Description: Erection of 39 houses and 12 apartments, with associated vehicular access, parking and public open space (outline application H04-0512-13) approved under H04-1081-13. Amendments to include change in Finished Floor Levels of Plots 4, 5, 6 and 7 changed to 3.250 AOD to be in line with the 2013 Flood Risk Assessment and garden fences re-arranged to rear of apartments (plots 37 - 48)

Amendment: Finished floor levels of Plots 4, 5, 6 & 7 changed to 3.250 to be in line with the Flood Risk Assessment (V2013)

PLANNING AMENDMENT

Drawing title **External Levels Plan**

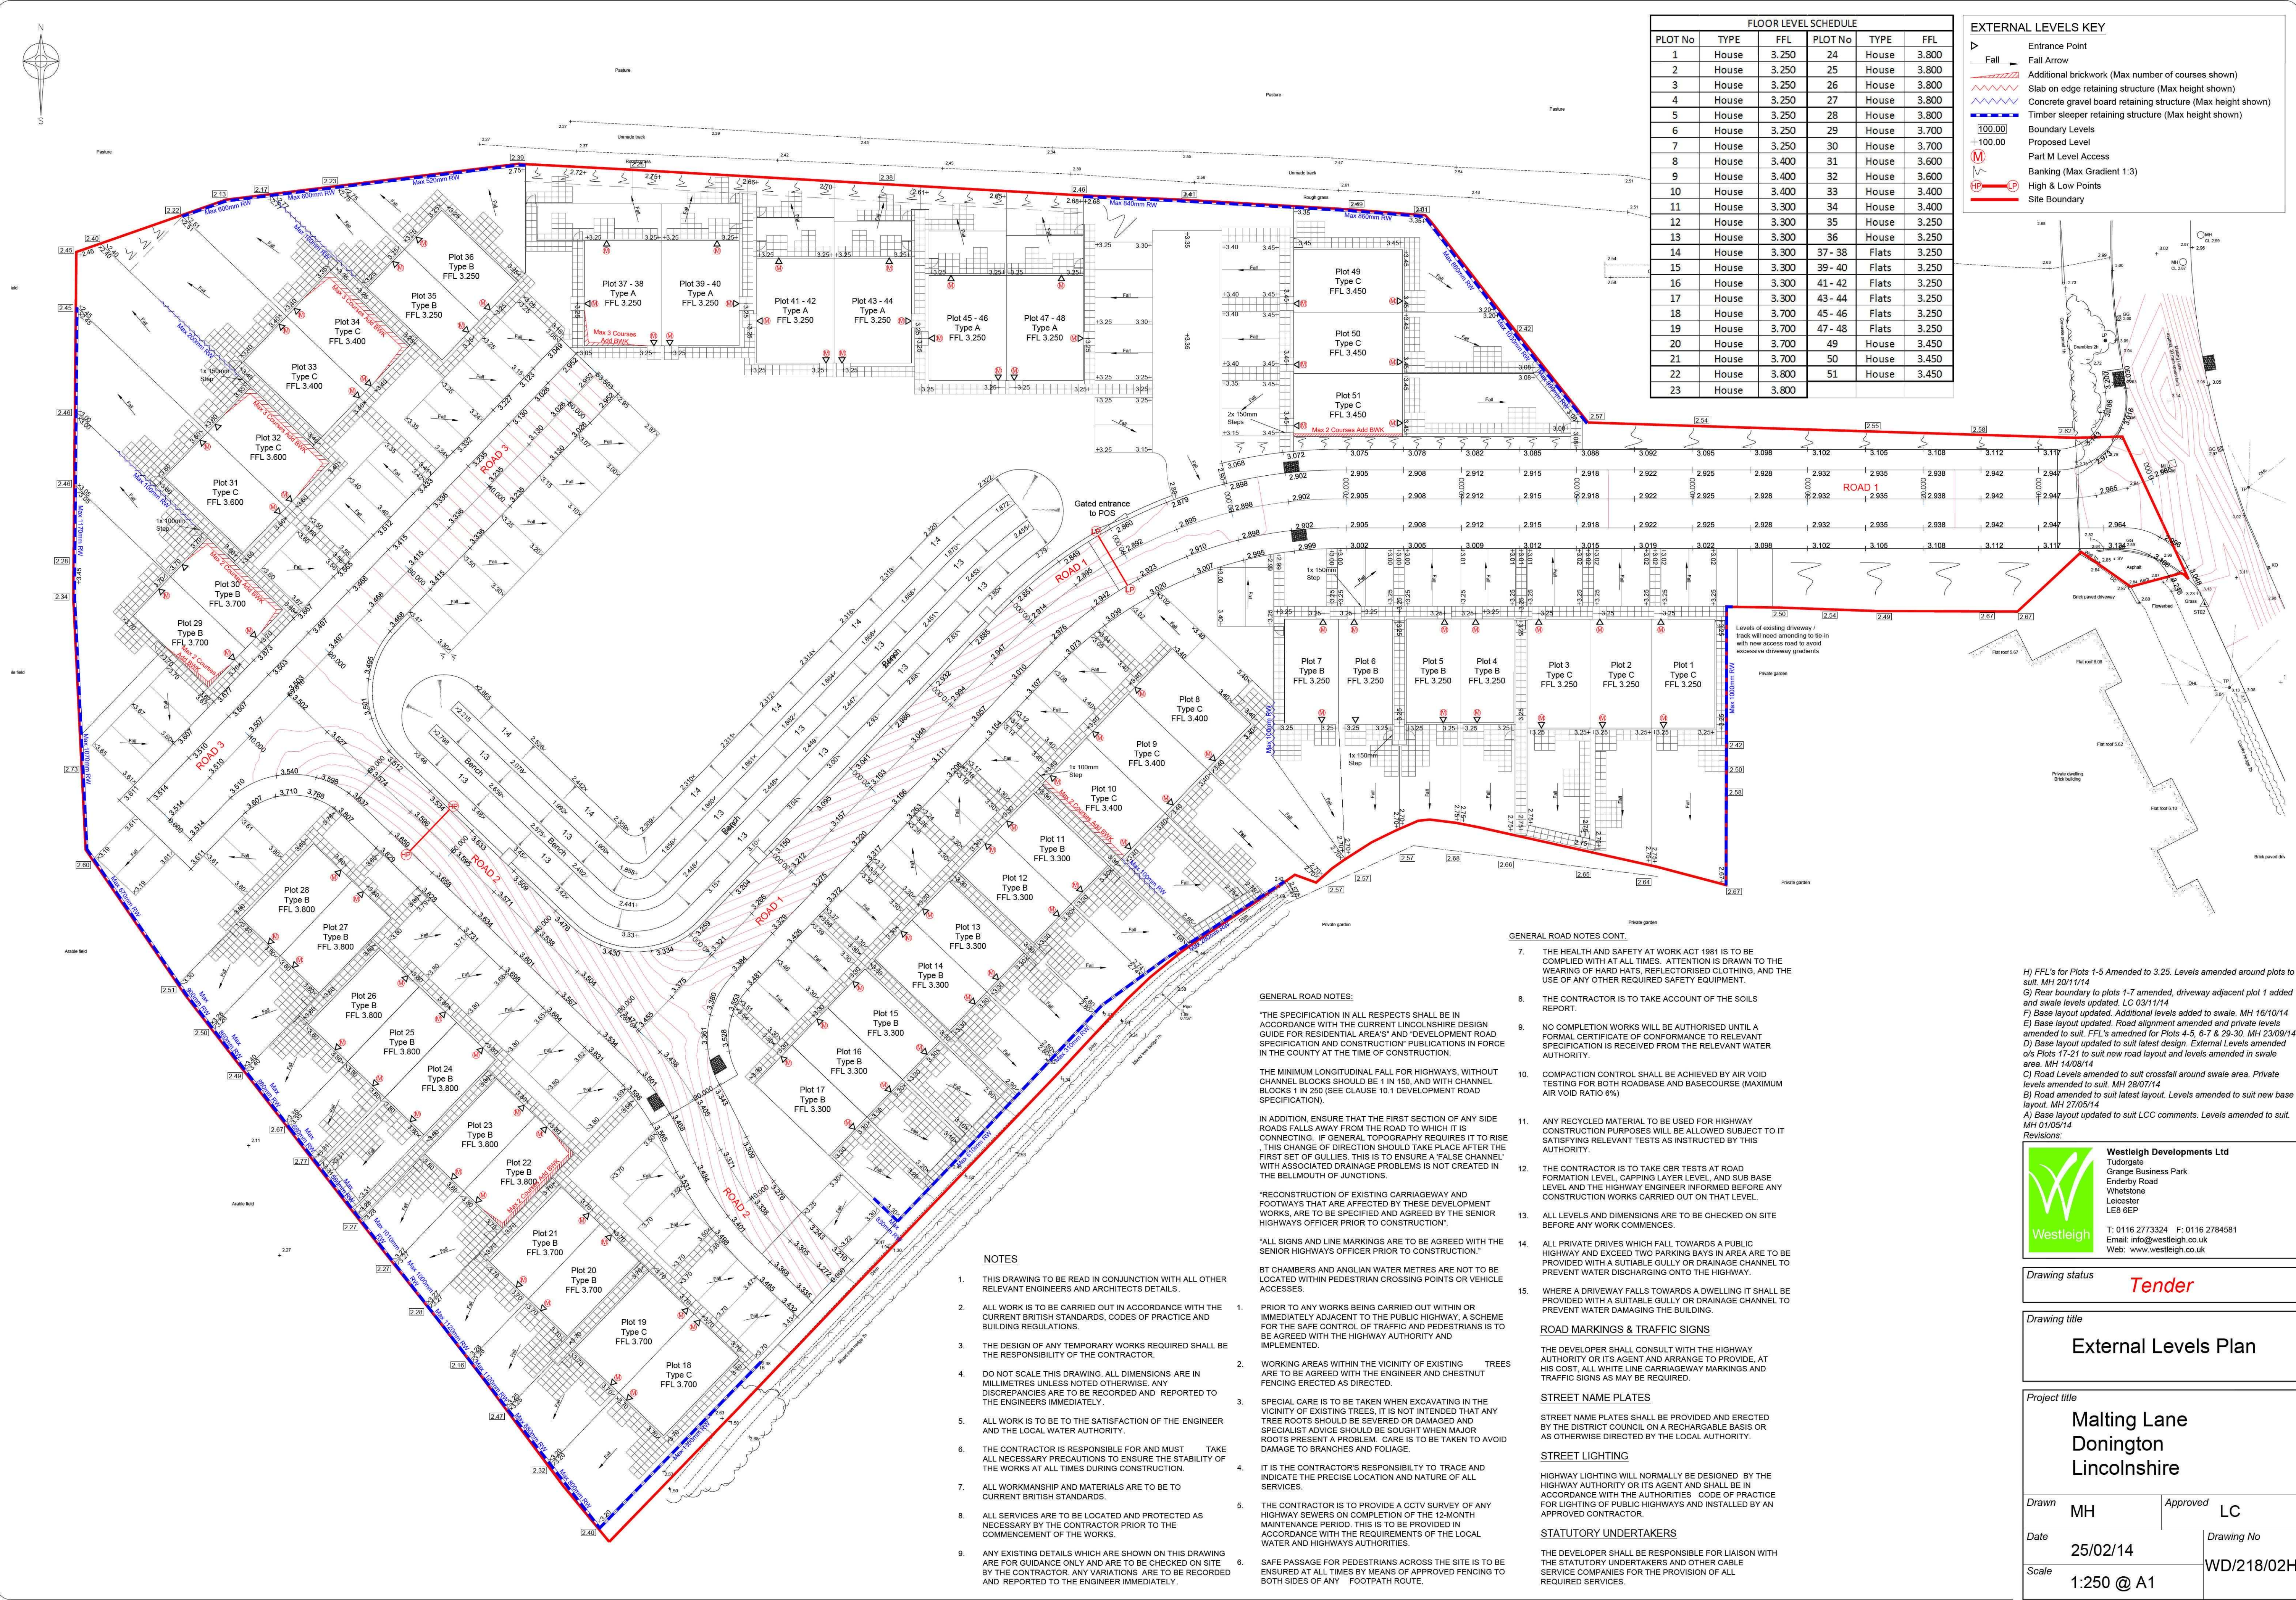
Following our discussions, I believe that the FFL amendments should remain part of the NMA application, you should find attached revised finished floor levels plan. The attached email from Rob Millbank should (as discussed) supersede Condition 2 of the Outline Planning Application (H04-0512-13) and instead use the 2013 FRA.
